CITY OF ALBUQUERQUE

Re: Tenant Improvement Project
6000 Montgomery Blvd NE
30-Day Temporary Certificate of Occupancy
Transportation Development Final Inspection
Engineer's/Architect's Stamp dated 11-20-20 (G18D042)
Certification dated 5-24-21

## 1 ARCHITECTURAL SITE PLAN

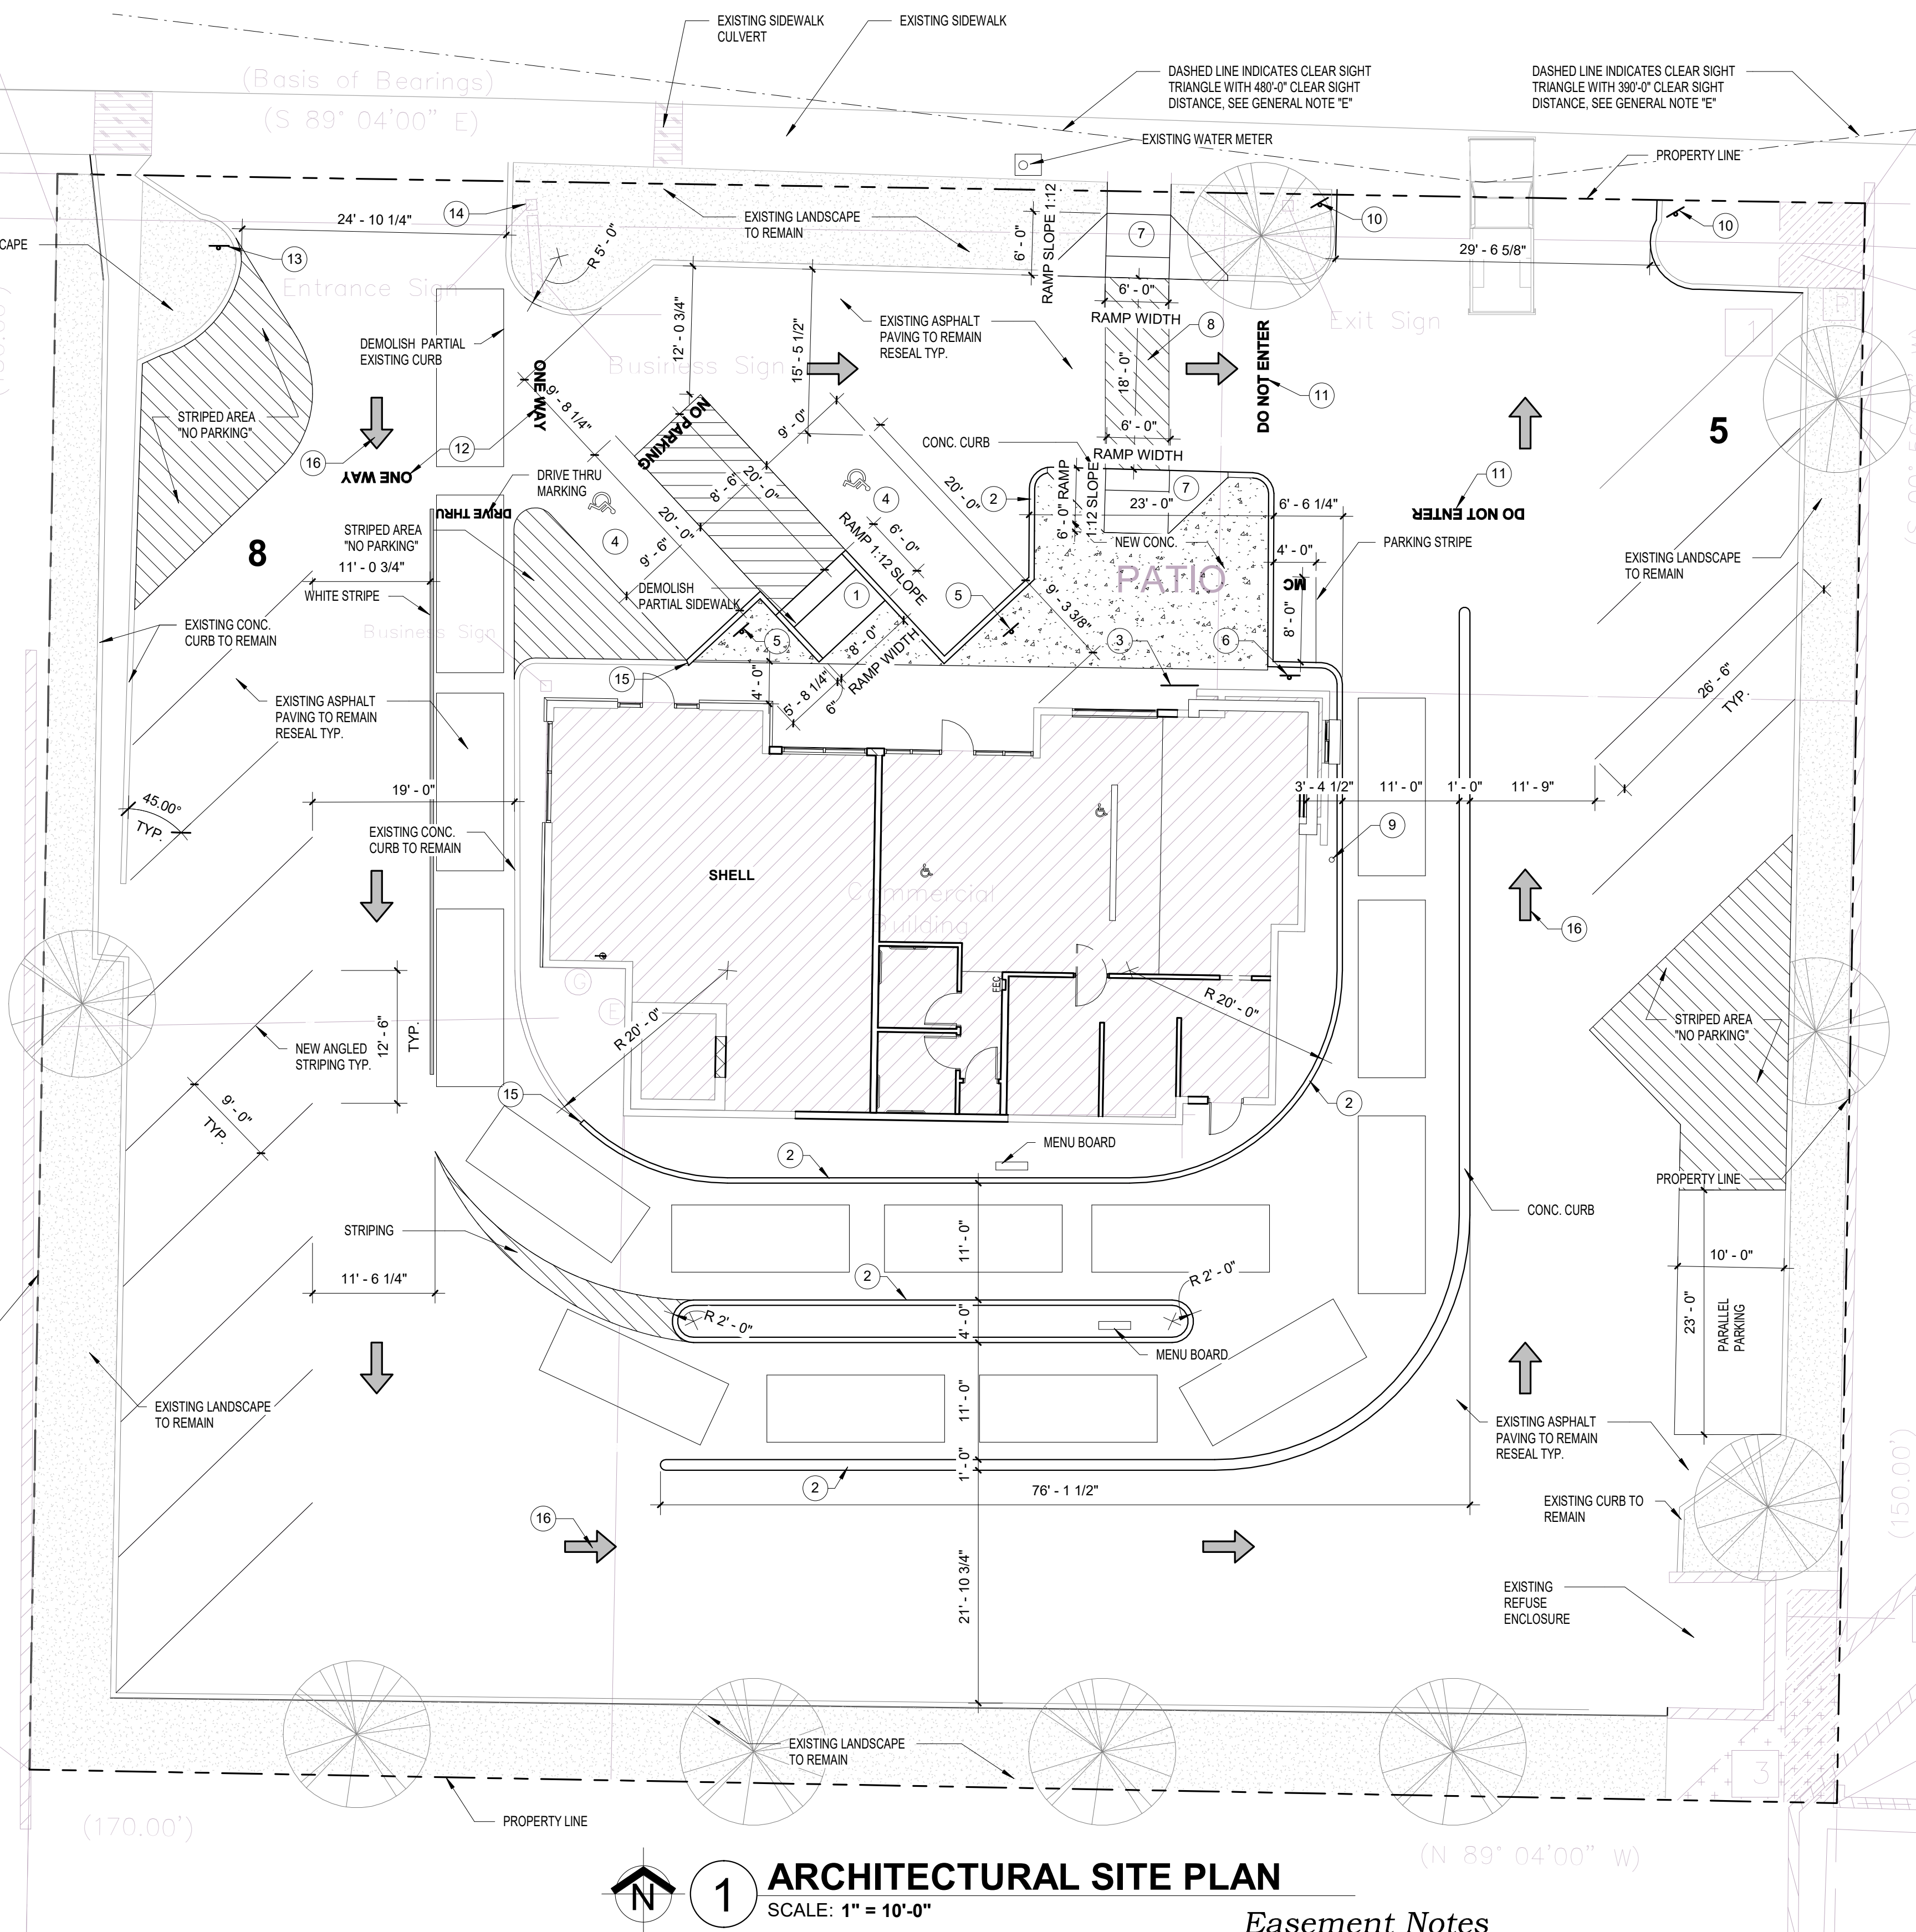
- Please add ADA signs with required language & One Way signs.
- Redline the Approved TCL.
- Remove construction debris and equipment.
